Our Ref: Y/103/18/PL
Your Ref:

Development Single Chapel Crematorium with car parking, landscape works, surface water drainage features & associated highway improvements. This application is a Departure from the Development Plan.

Location 10 Acre Field North of Grevatts Lane Yapton

I regret that I am unable to accept your documents as a formal application until the following item(s) have been received or resolved :-

Drawing Title:
GA Ground Floor Plan

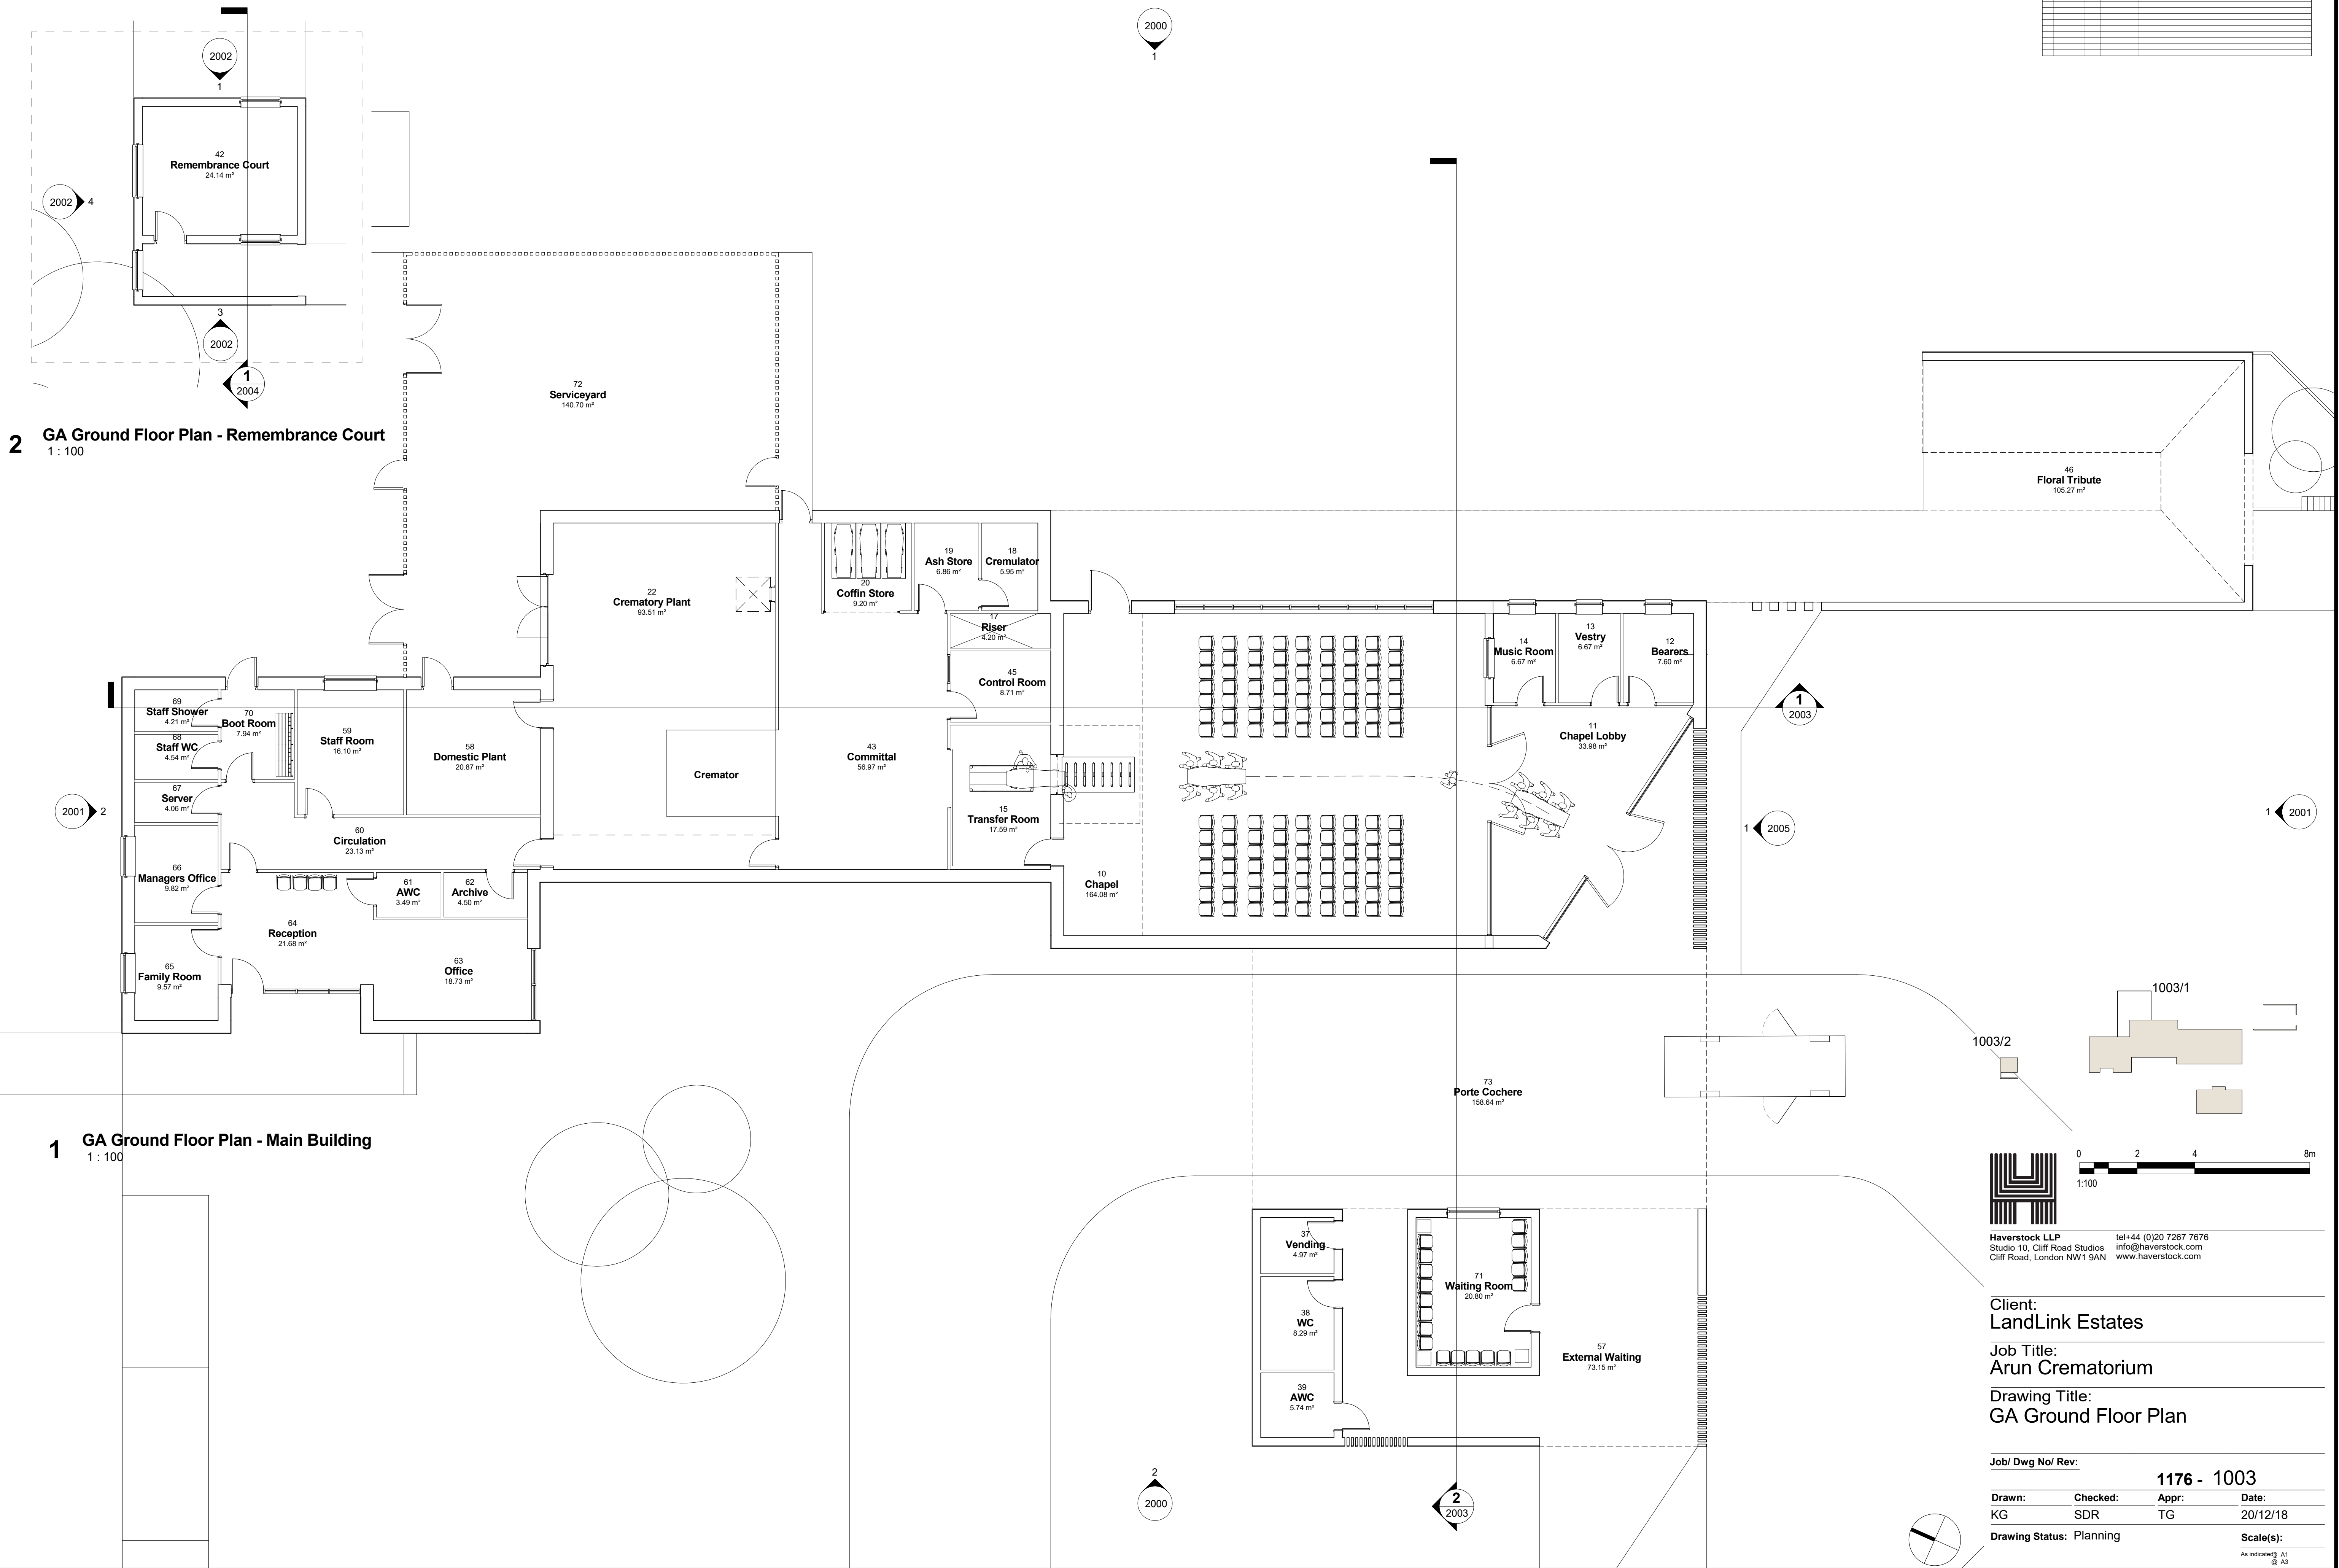
On the proposed ground floor plan, please check that the north point is correct. If you feel the north point is correct, please email to that affect. If the north point is not correct, please update the plan accordingly.
